Our Case Number: ABP-322244-25

An
Coimisiún
Pleanála

Date: 26 June 2025

Re: Proposed works at Galbally Bridge, Moorabbey, County Limerick.
Mandeville Park, Moorabbey, County Limerick.

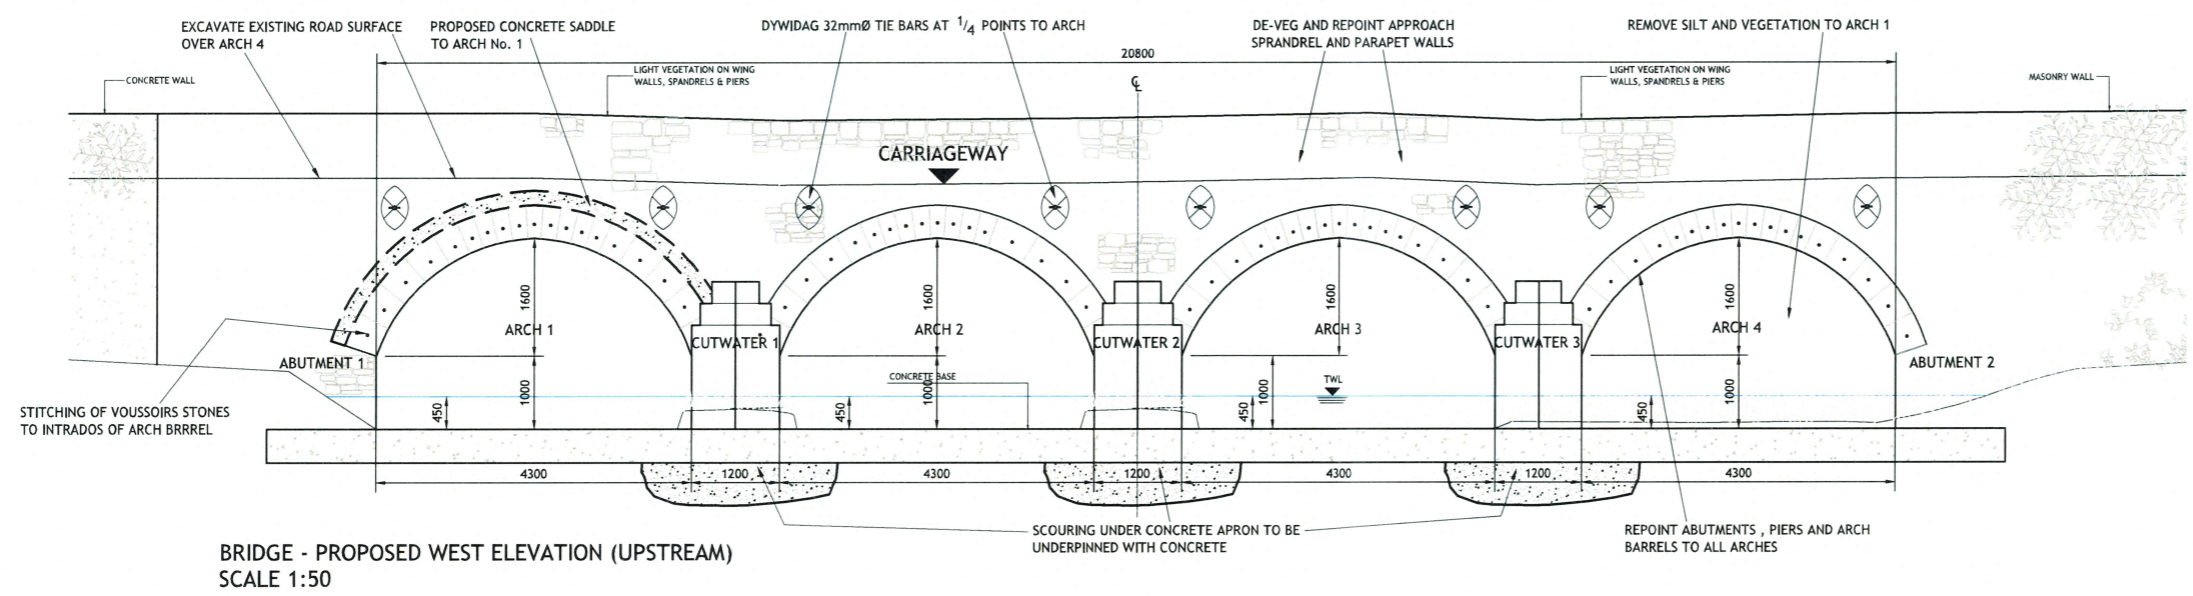
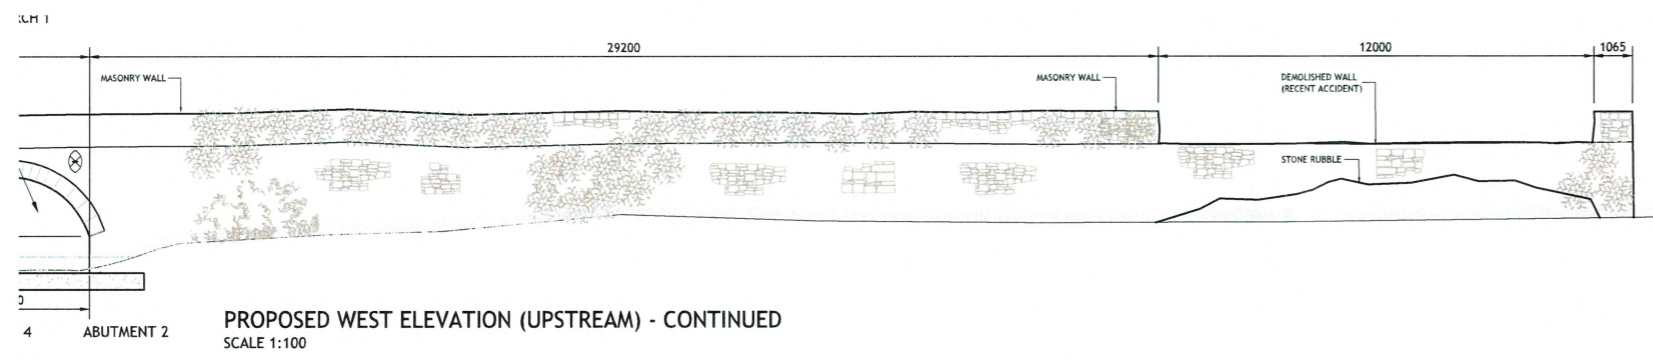
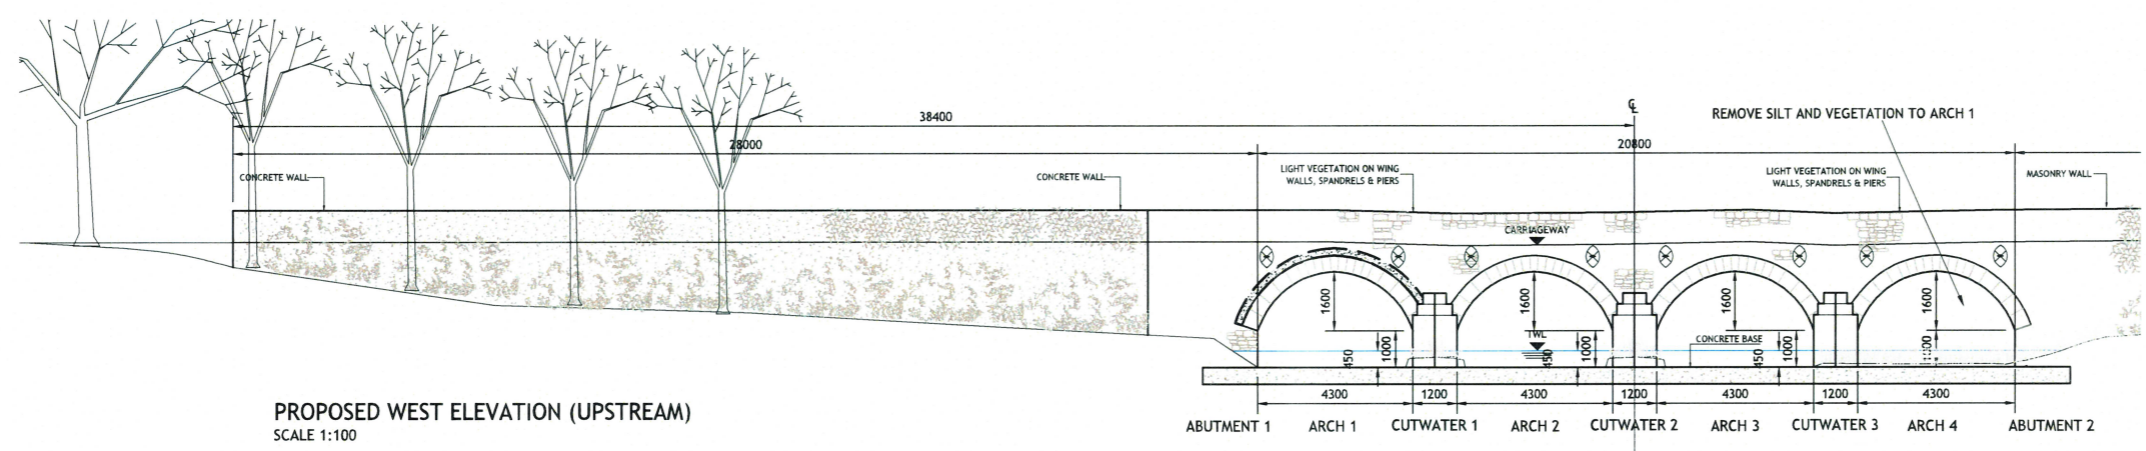
- (iv) details of the replacement of any stonework or any works of re-pointing which shall be undertaken so that it matches the original existing bridge finish,

4. The detailed specification of the proposed concrete lintels to improve the flow pattern should be discussed with Inland Fisheries Ireland. Since this would seem to involve a large amount of concrete, it is recommended that only pre-cast and fully cured concrete is used (this has not been specified in the Natura Impact Statement).
